Application Reference: 2026/0588

Site Address: 1 Prospect, Thurlstone, Sheffield, S36 9RA

Introduction: This application seeks full planning permission for the conversion of attic space to create habitable area and install of rear dormer to dwelling

Drawing Title: Plans & Elevations - Proposed

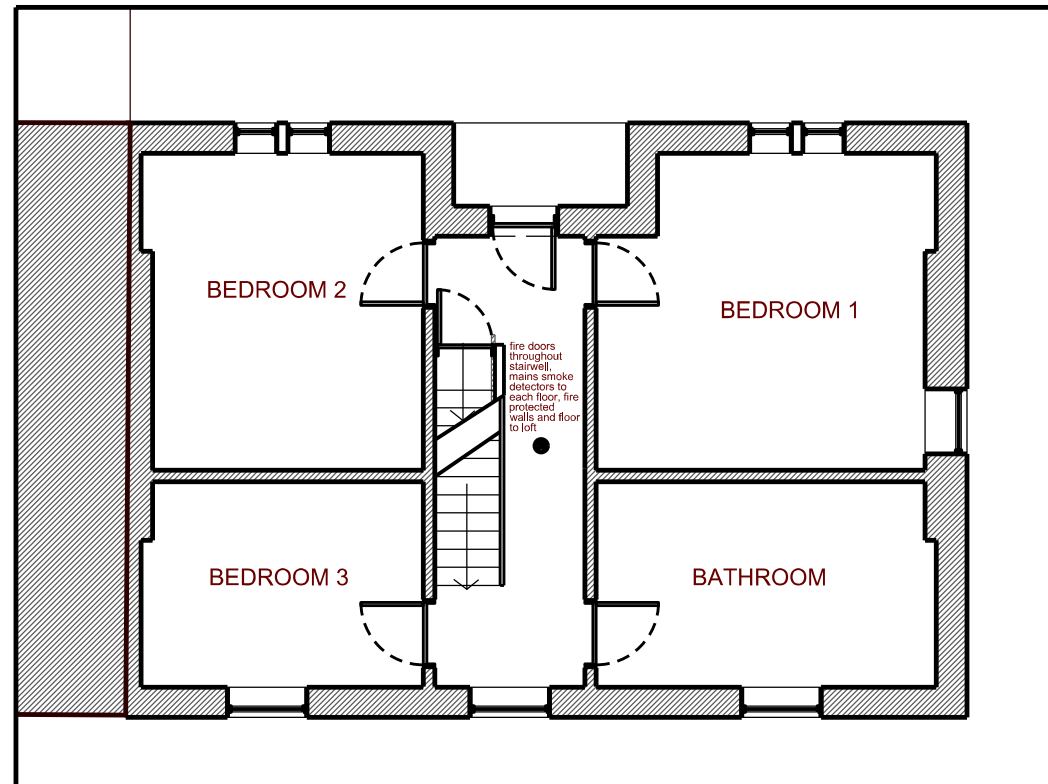
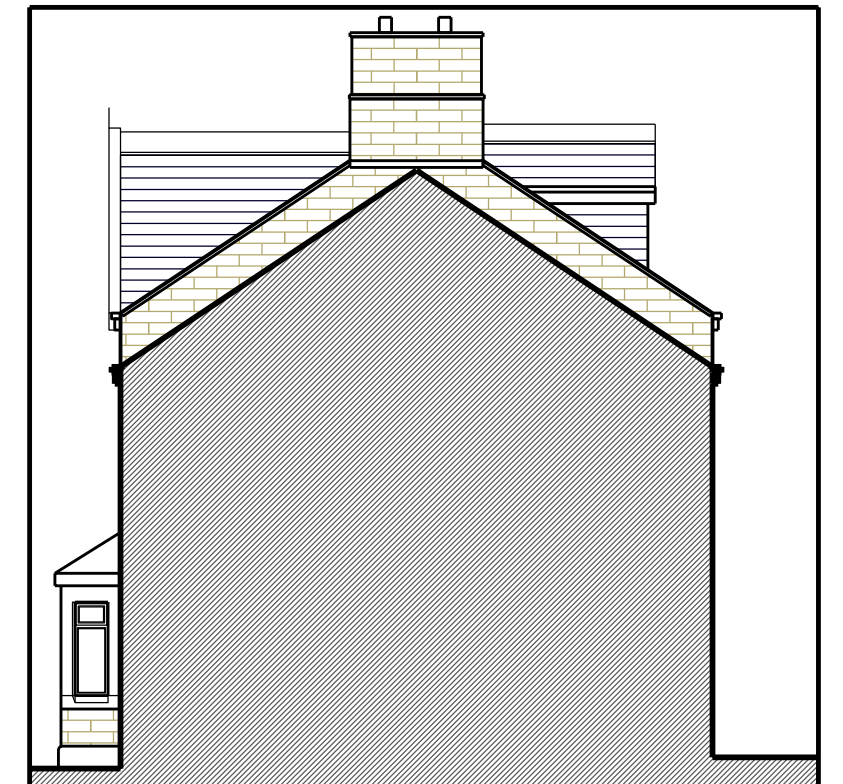
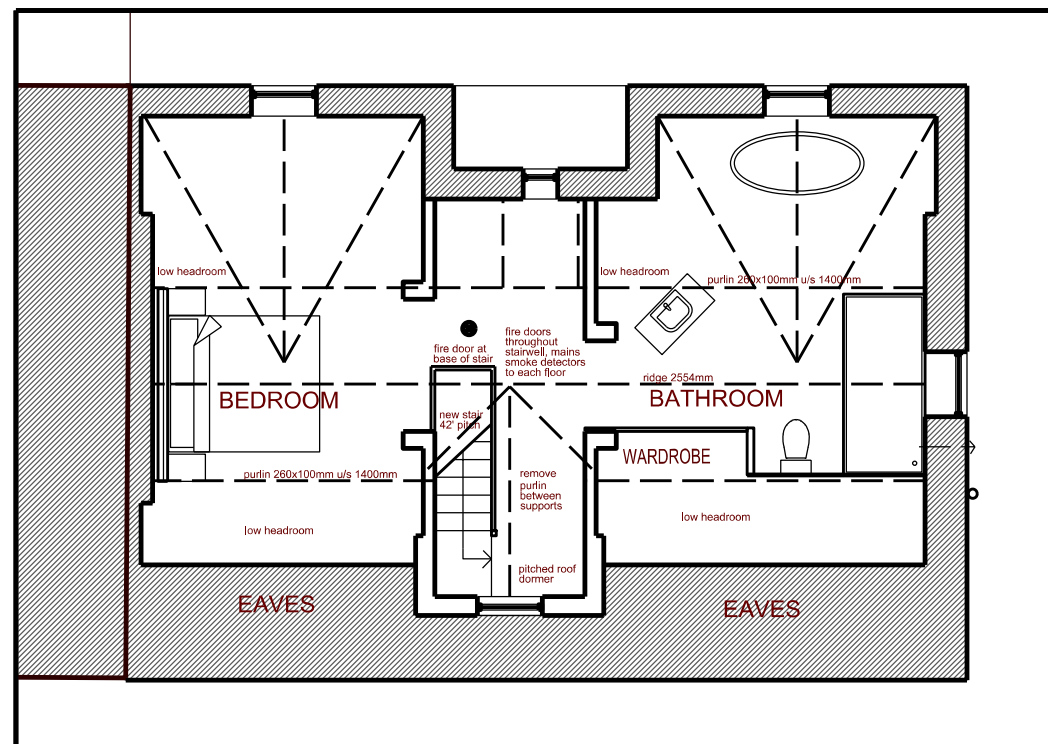
With proposed measurements of approximately 2.28m in projection, a height of 1.94m and a width of 2.49m, the volume of the dormer would equate to approximately 5.1 cubic meters in volume.

Whilst the actual scale and volume of the proposed dormer is relatively modest and would not be a dominant feature within roof plane, it would be visible and would not meet the full recommendations for the positioning of dormers, as outlined in the SPD House Extensions and other Domestic Extensions. The position of the dormer is not exactly an equal distance between the side elevations of the dwelling but instead is aligned with the middle of three first floor windows below the roofline, and as suggested in the SPD is set more than 0.5m away from the party wall, the gable, and the eaves of the dwelling.

The submitted Design and Access Statement confirms that the window frame within the dormer would be of a proportionate scale and design to those within the original dwelling and that the dormer would be clad in natural slate of a close as match as possible to the original dwelling. This supports the integration of the dormer with the dwelling and broader street scene despite being set higher than usually recommended.

Additional modest alterations detailed on the plans include the replacement of a second storey side elevation window, but this would seemingly be of similar appearance, retaining the scale of the original window and external features, limiting any impact on scale design and character of the original dwelling. An extension of the existing soil pipe, including two small additional branches is also proposed. This would serve the amended internal layout of the dwelling and would have little or no impact to the overall scale and design of the dwelling.

The proposed front dormer window would only directly overlook Prospect, parking provision, and the literal rock face below Rockside Road which passes by Prospect at a considerable height. With the proposed side elevation window appearing to be a like for like replacement, and it only overlooking the blank side elevation of no 1A Prospect, there would be little or no impact on neighbouring amenity.
